**Harnett County**  
420 McKinney Pkwy  
LILLINGTON, NC 27546  
Phone:  
Fax:

**SUBJECT: BCOM2207-0003  
BUILDING COMMERCIAL**

To: ANDERSON CREEK CLUB CHARTER SCHOOL INC

Here are the results of all Inspections located at **4940 RAY RD:**

MOBILE CLASSROOM FOUNDATION PLAN
 1
 1/4" = 1'-0"

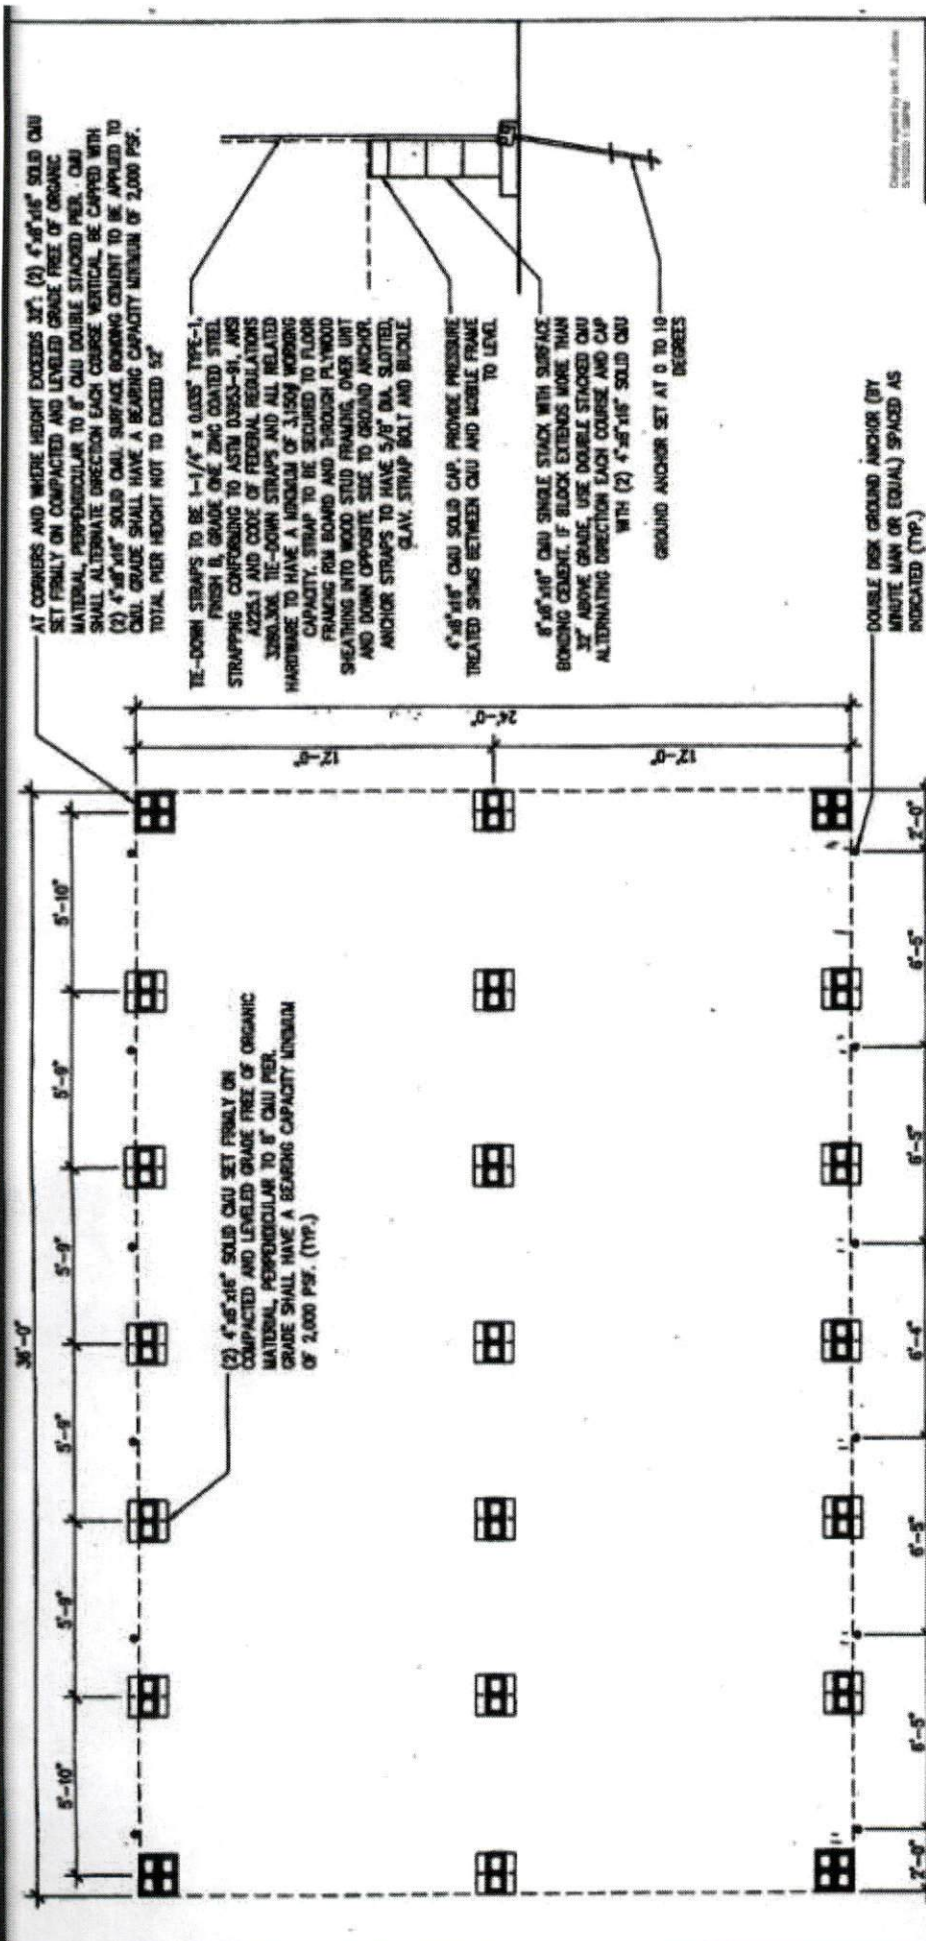
Inspection Type: FINAL\*\*  
Scheduled Date/Time: 1/9/2023  
Completed Date/Time: 1/9/2023  
Inspector: James T Hall  
Result: DISAPPROVED  
Remarks:  
Notes: Need to remove under pinning for foundation inspection before final
